In reply please quote: 17/22684

10 January 2022

SSD-8859 – REQUEST FOR ADVICE TO RESPONSE TO SUBMISSIONS FOR PROPOSED SUBDIVISION TO 1111-1141 ELIZABETH DRIVE, CECIL PARK

Figure 9 | Final concept roadway and intersection design

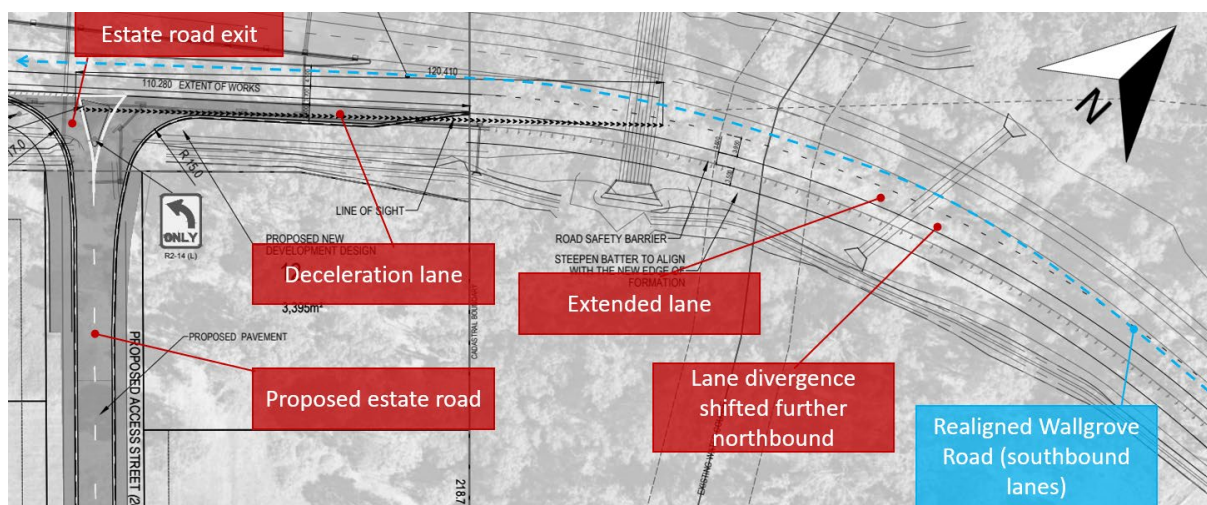
1. As vehicles turning left from the realigned Wallgrove Road onto the access road approaching the subject site would impact motorists' sight distance when exiting the access road.

A Safe Intersection Sight Distance (SISD) assessment must be undertaken by the applicant in accordance for the proposed intersection of the new access road and the realigned Wallgrove Road to demonstrate that the road design complies with Austroads requirements – Guide to Road Design Part 4A: Un-signalised and Signalised Intersections. The assessment shall be shown on a SISD diagram and this information shall be submitted to Transport for NSW and Council for assessment. This issue shall be also addressed as a result of the findings of the Road Safety Audit.
